Fire Marshal Division

**Re: Central Harnett Hospital
215 Brightwater Drive
Lillington, NC 27546**

Application Number BCOM1809-0003

1 FIRST LEVEL FLOOR LIFE SAFETY PLAN  
 1/16" = 1'-0"

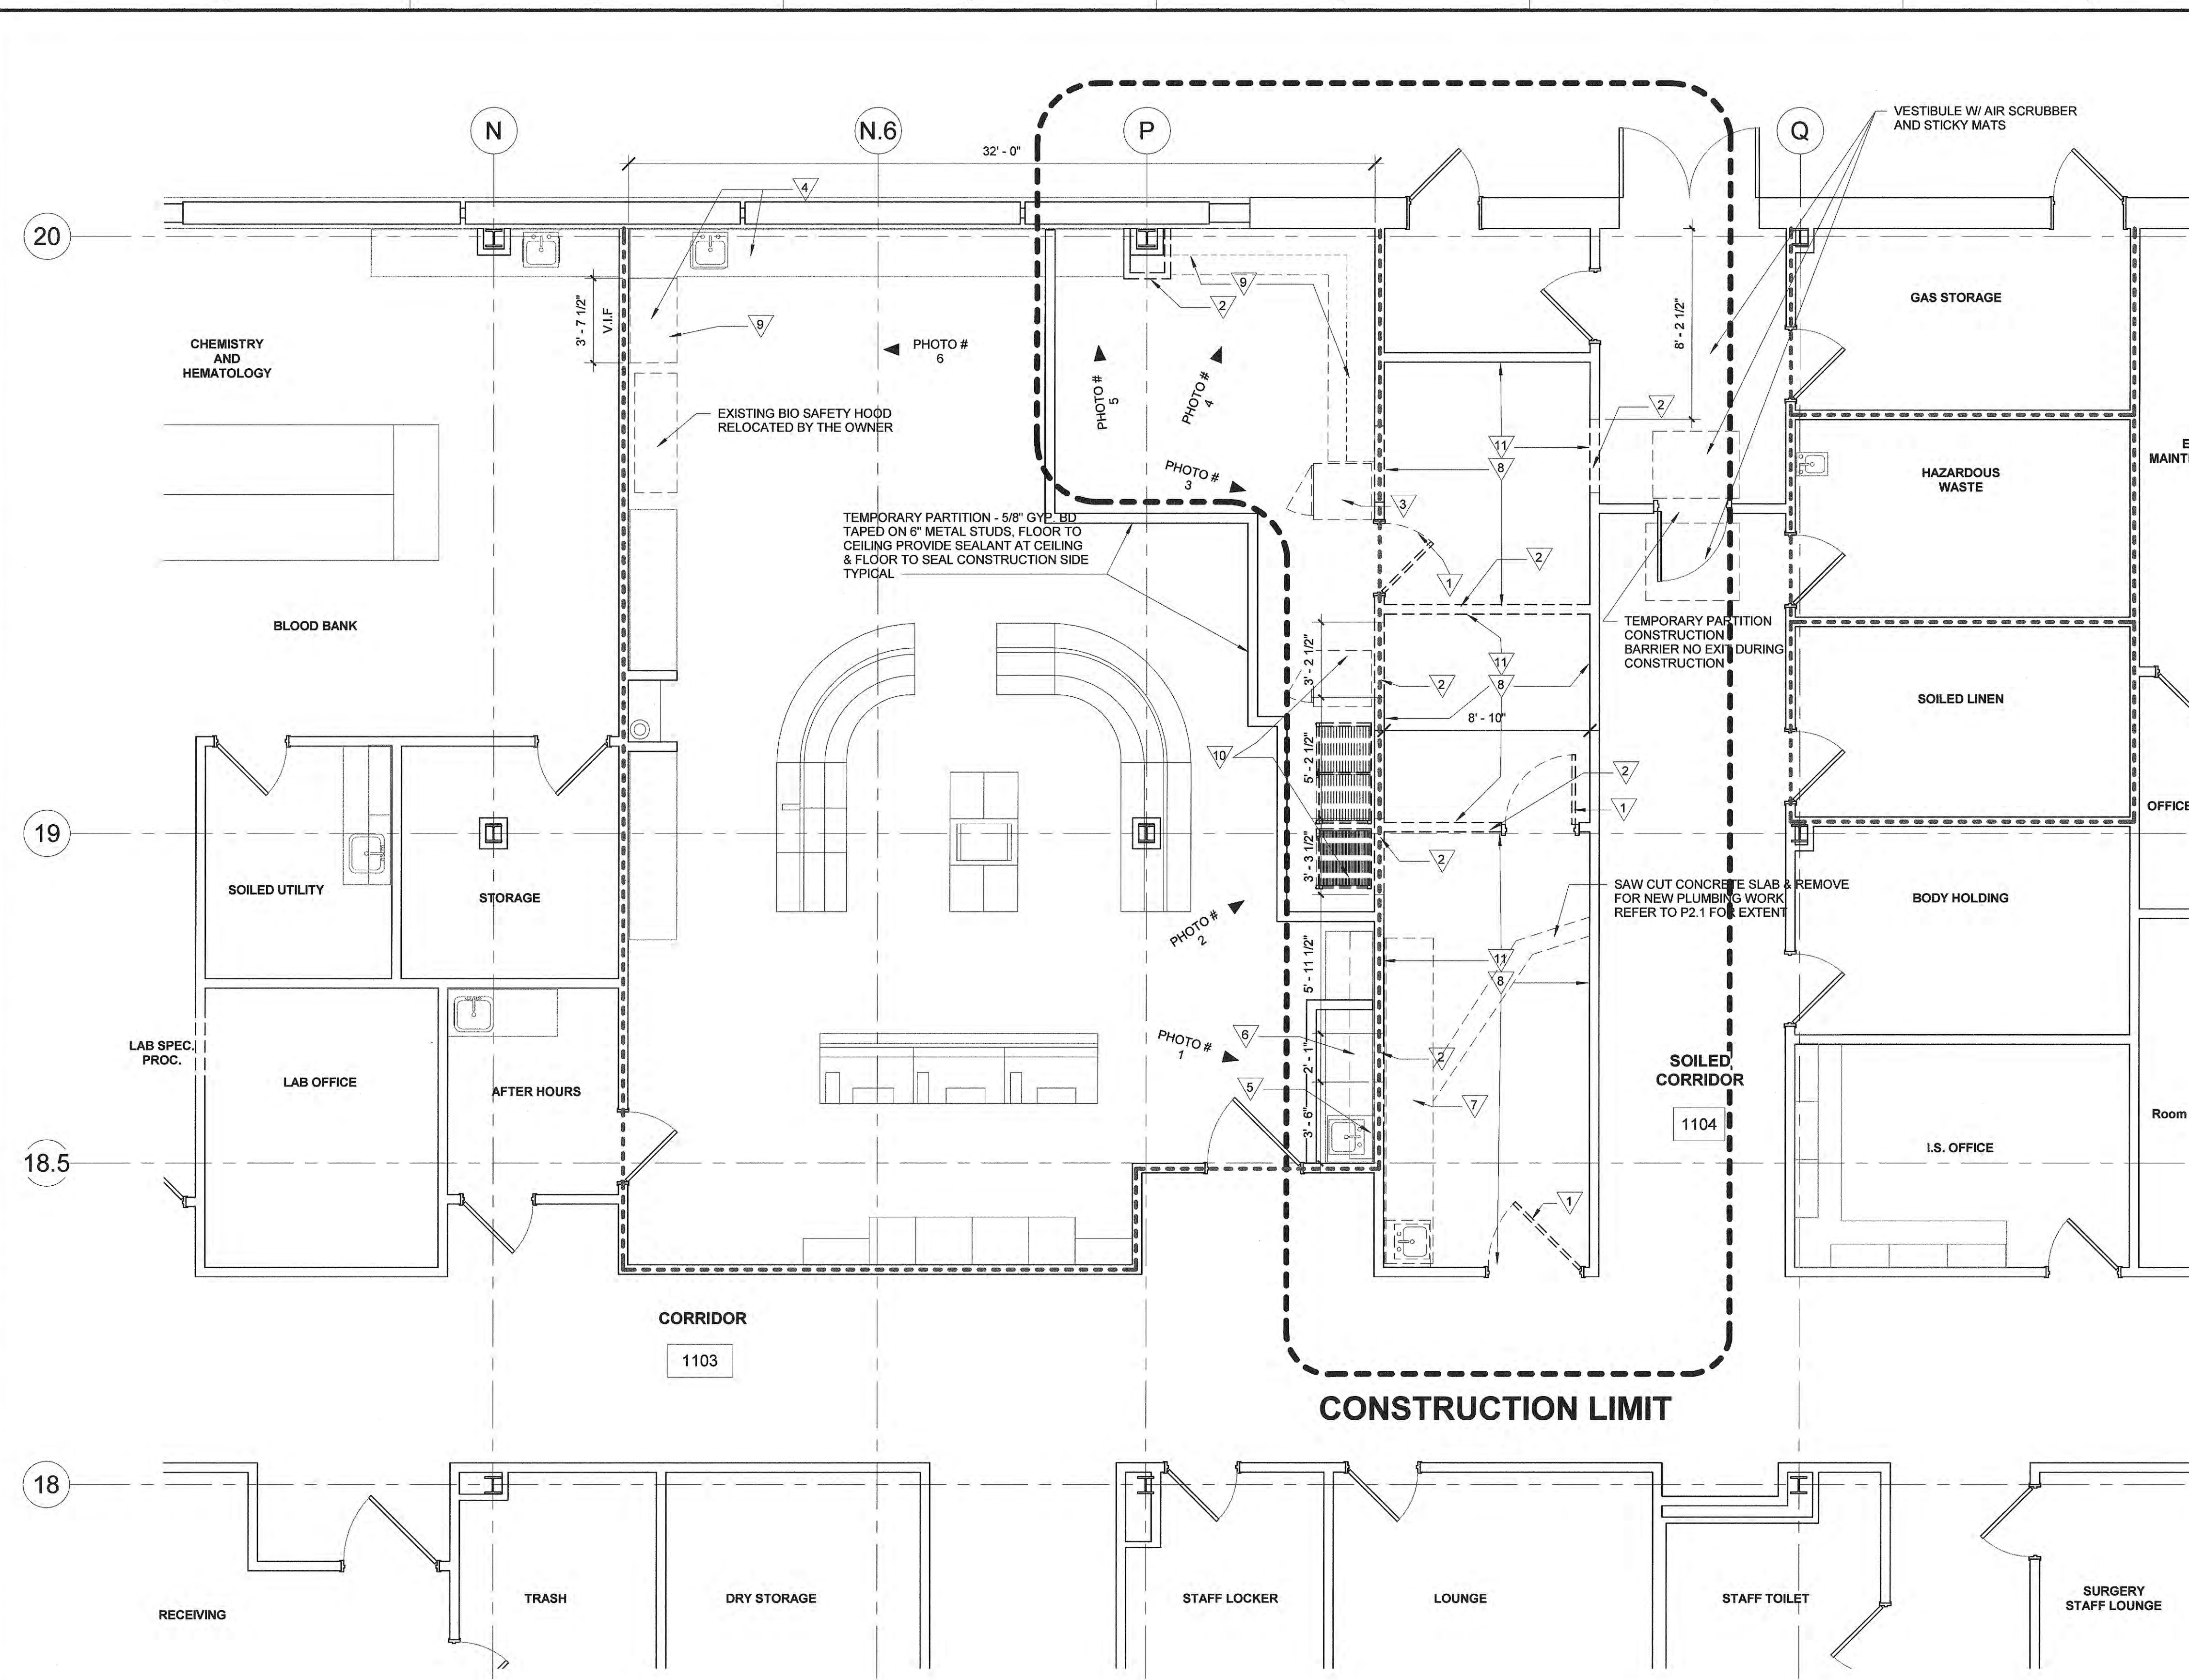
- **906.1 Fire Extinguishers**
 - Minimum of (1) 2A:10BC fire extinguisher shall be installed not to exceed 75' distance of travel.
 - All Fire extinguishers shall be properly mounted and tagged by a fire extinguisher company.

**7 DOORS A1813, A1815 AND A1817 SECURITY DETAIL**  
NTS

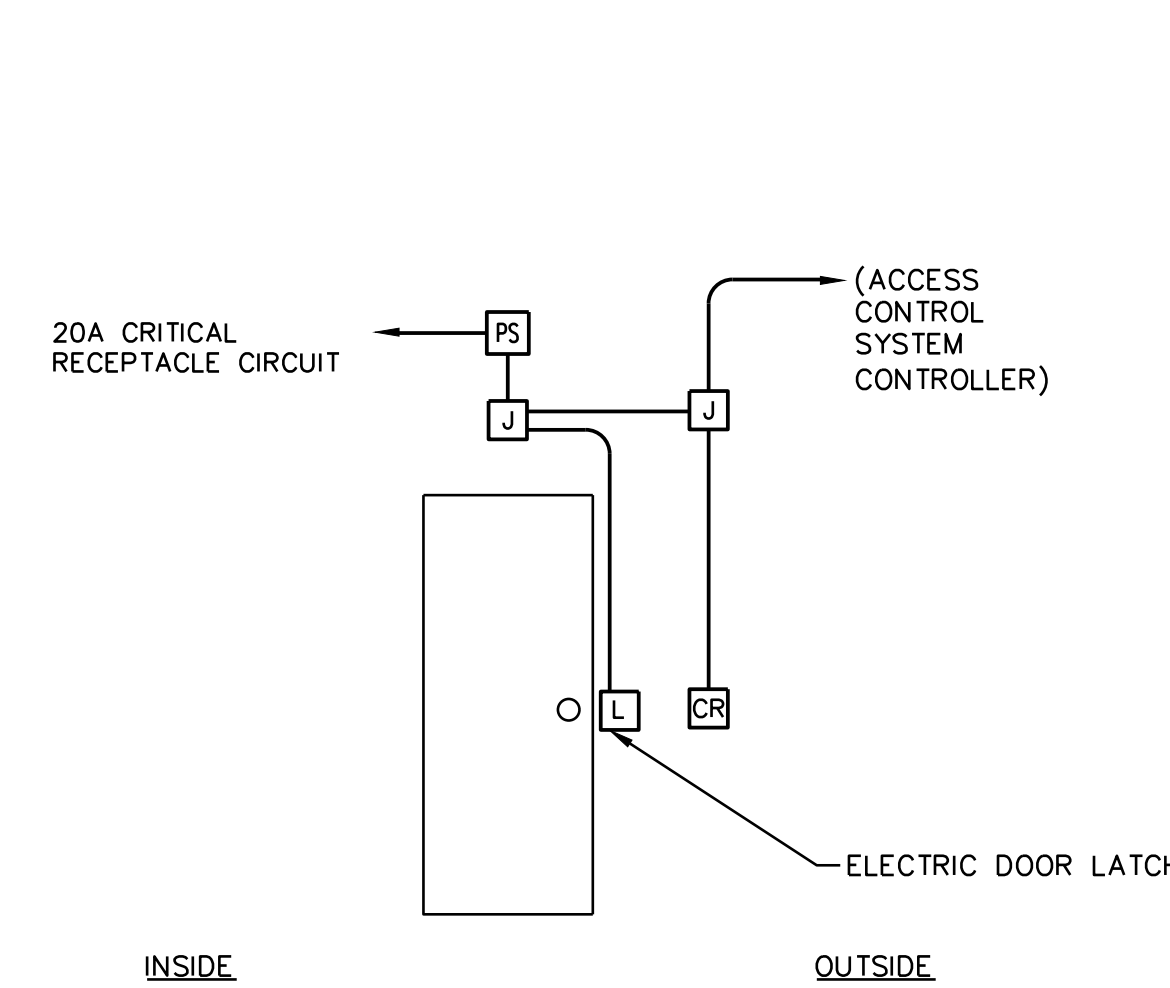
- **1008.1.4.4 Access-controlled egress doors.**
 - The entrance doors in a *means of egress* in buildings with an occupancy in Group A, B, E, I-2, M, R-1 or R-2 and entrance doors to tenant spaces in occupancies in Groups A, B, E, I-2, M, R-1 and R-2 are permitted to be equipped with an *approved* entrance and egress access control system which shall be installed in accordance with all of the following criteria:

1. A sensor shall be provided on the egress side arranged to detect an occupant approaching the doors. The doors shall be arranged to unlock by a signal from or loss of power to the sensor.

2. Loss of power to that part of the access control system which locks the doors shall automatically unlock the doors.
3. The doors shall be arranged to unlock from a manual unlocking device located 40 inches to 48 inches (1016mm to 1219 mm) vertically above the floor and within 5 feet (1524 mm) of the secured doors. Ready access shall be provided to the manual unlocking device and the device shall be clearly identified by a sign that reads "PUSH TO EXIT." When operated, the manual unlocking device shall result in direct interruption of power to the lock— independent of the access control system electronics—and the doors shall remain unlocked for a minimum of 30 seconds.

4. Activation of the building fire alarm system, if provided, shall automatically unlock the doors, and the doors shall remain unlocked until the fire alarm system has been reset.

5. Activation of the building automatic sprinkler or fire detection system, if provided, shall automatically unlock the doors. The doors shall remain unlocked until the fire alarm system has been reset.
